One Earth Solar Farm

Draft Statement of Common Ground with Historic England

EN010159/APP/8.7.1

October 2025

Figure 16: Second iteration of masterplan presented at statutory consultation

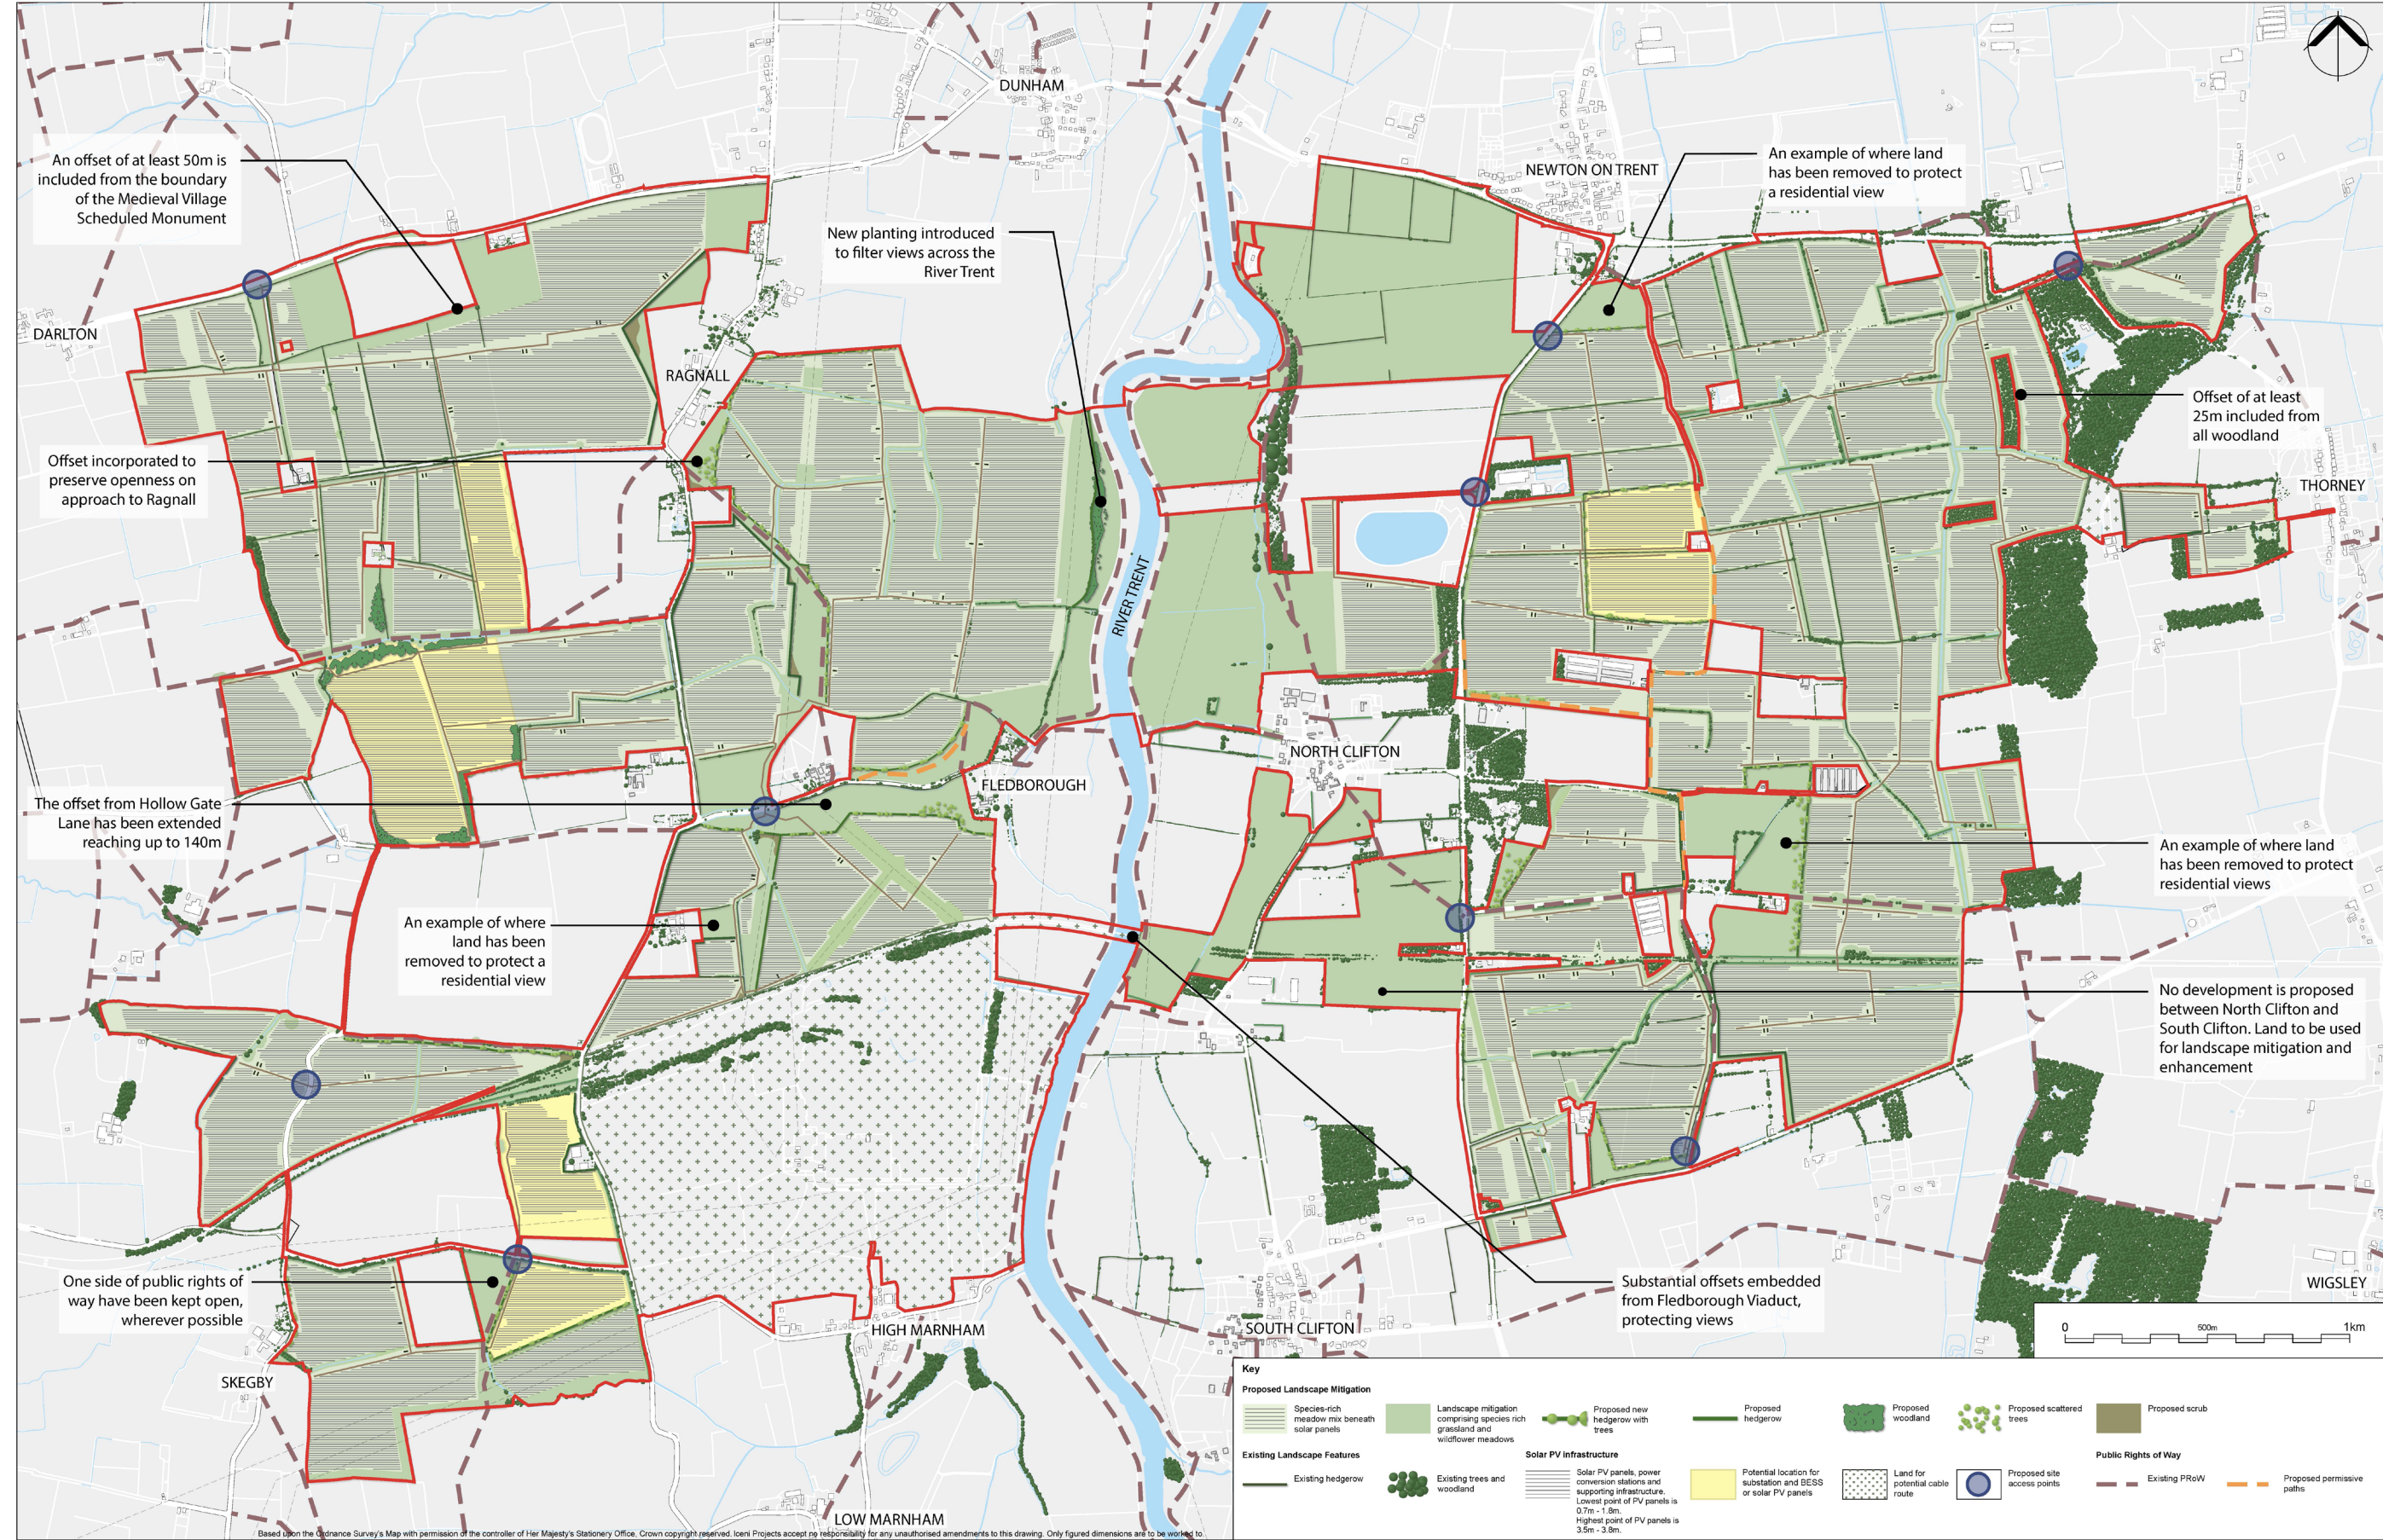
in December 2024 – January 2025.		
02-08	Impact on built heritage assets	<p>Historic England raised concerns on the proximity of the solar panels to the south of Whimpton Moor SM. Larger buffer suggested, “possibly by removing the triangular area of panels to the brown line indicated on the masterplan”.</p> <p>Further detail can be found in Historic England’s Statutory Consultation Response (reference can be provided upon request) in July 2024, and in Relevant Representation [RR-019, 191], as well as email correspondence in December 2024 – January 2025.</p>	<p>Further detail can be found in Table 10.5 of ES Chapter 10: Cultural Heritage [APP-039]. The effect on Whimpton Moor Scheduled Monument has been assessed in ES Chapter 10 at 10.6.39 – 41 [APP-039].</p> <p>Whilst the concerns on the proximity of development to the south are noted, this has been designed in response to the topography and would not be visible in views of the Scheduled Monument (see Figure 11.13.13A; 11.13.13B [AS-039]). See response to Relevant Representation [RR-019, 191] for further detail.</p>	Under Discussion
